RTA Ref: RDC 09M177 SYD10/00995
Contact: Pahee Sellathurai T 8849 2219
DoP Ref: MP08_0244

**SYDNEY
REGIONAL
DEVELOPMENT
ADVISORY
COMMITTEE**

**MIXED USE COMMERCIAL, RETAIL, AND RESIDENTIAL DEVELOPMENT
23-37 LINDFIELD AVENUE AND 11 HAVILAH AVENUE, LINDFIELD**

RL 94.00  
**LOWER GROUND  
 FLOOR PLAN**  
 SK 0 2

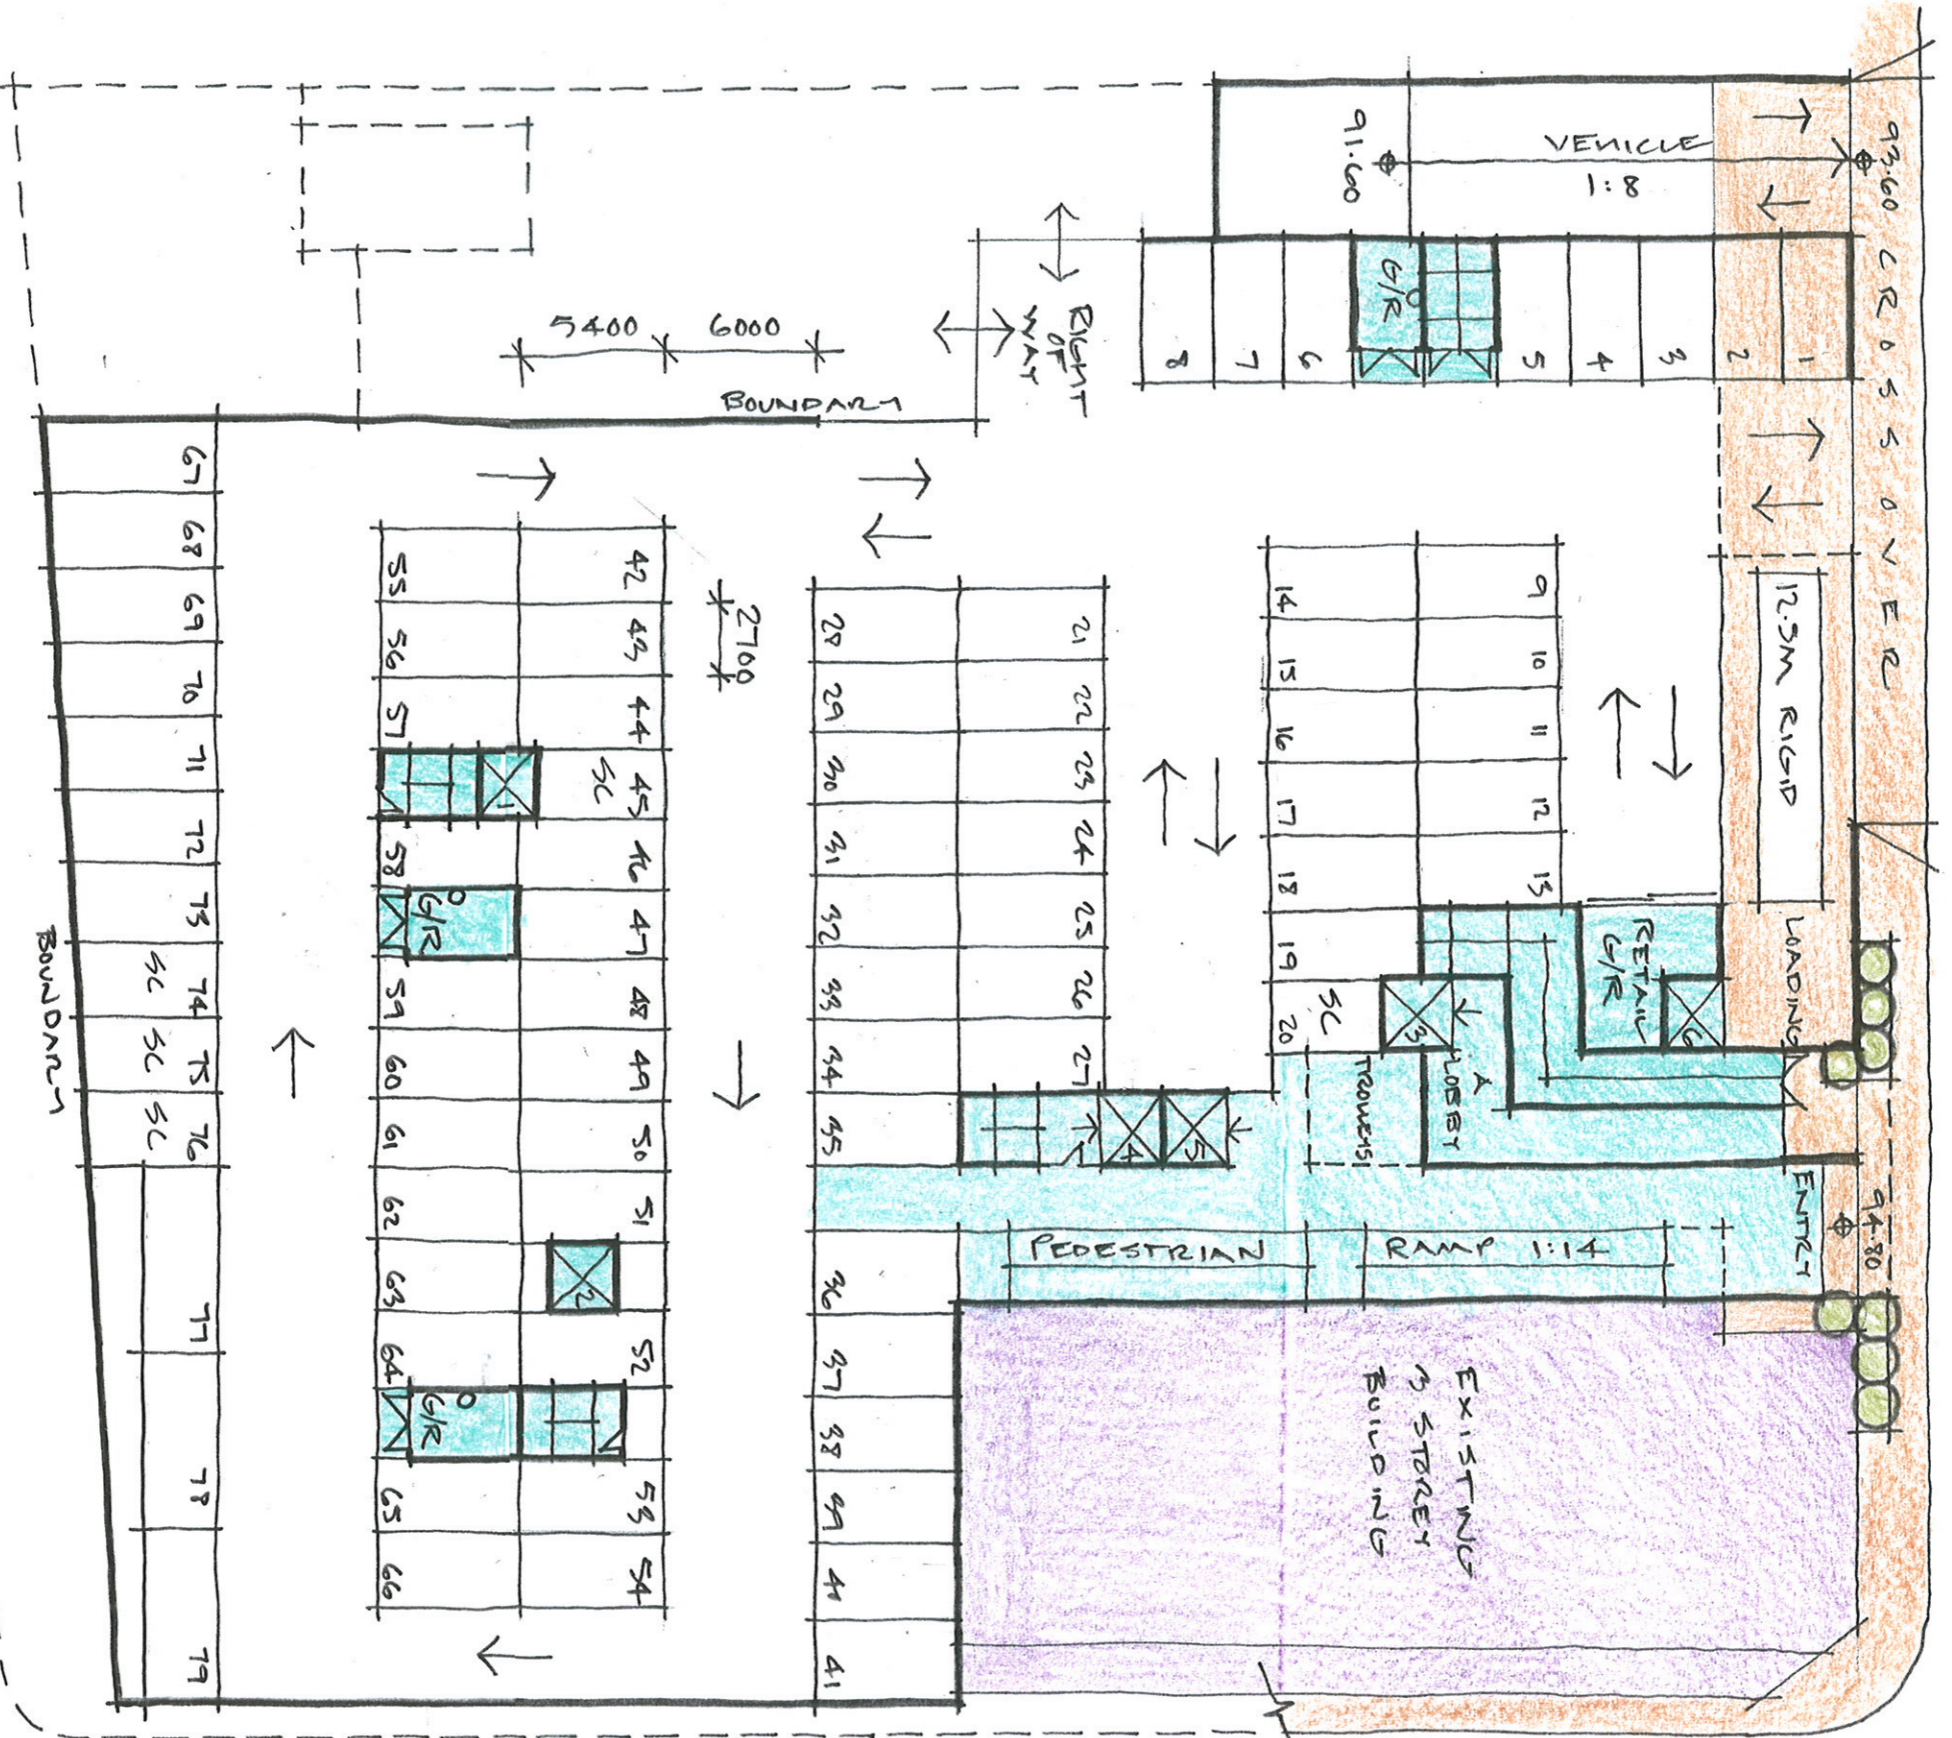
The RTA raises concerns regarding the car park driveway width, circulation within the lower ground car park, stacked parking spaces for car share scheme and the angle parking spaces in both basement level and lower ground level car park. A revised plan addressing these concerns should be submitted to the Department of Planning and the RTA for review.

The revised plan should demonstrate compliance of driveway width with the Australian Standard, remove the conflicting points within the lower level ground car park and remove the angle parking.

5. Retail parking should be separate from residential parking and should be clearly sign posted. It is noted that the lower ground level car park contains both residential and retail car parking spaces. The applicant should outline the mechanisms to prevent retailers from using residential car parking spaces.

RL 91.20
BASEMENT 1
FLOOR PLAN
SK 01

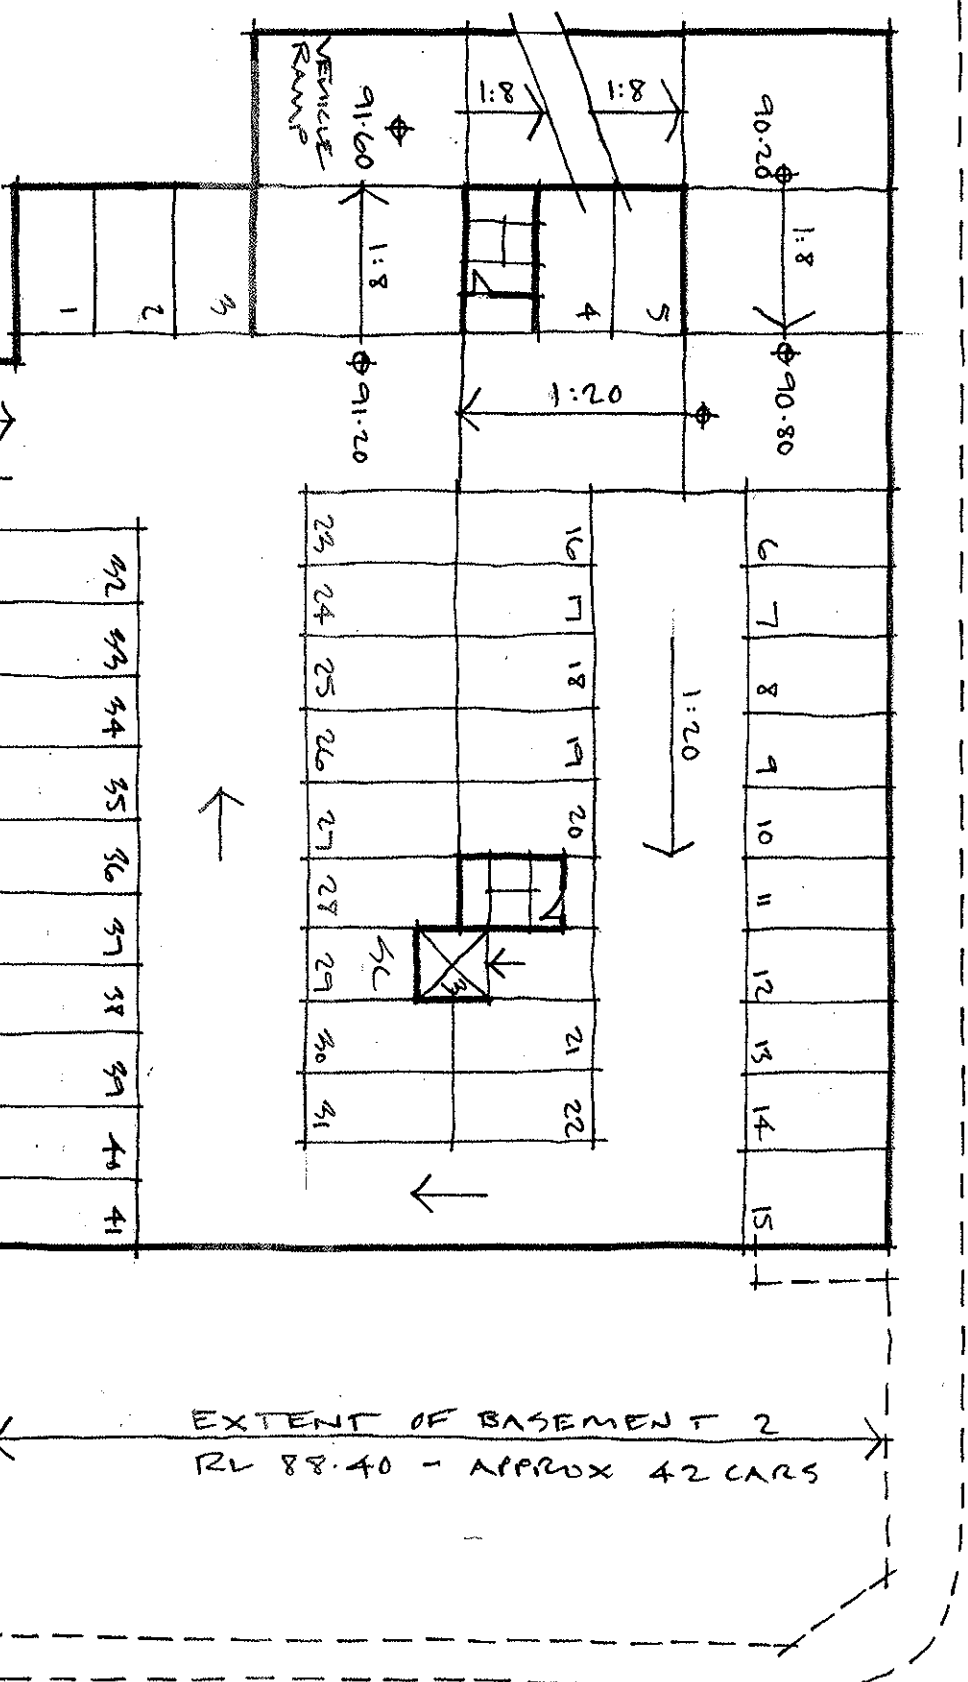
2. The RTA raises concerns regarding the number of car parking spaces provided for the retail component of the development. It is noted that while 102 car parking spaces (which is more than the required minimum of 98 spaces) are provided for the residential component of the development, only 48 car parking spaces (which is well below the required minimum of 99 spaces) are provided within the basement car park. Consideration should be given to provide minimum required car parking spaces for the retail component of the development within the basement car park. Provision of these car parking spaces may require the construction of an additional basement level.
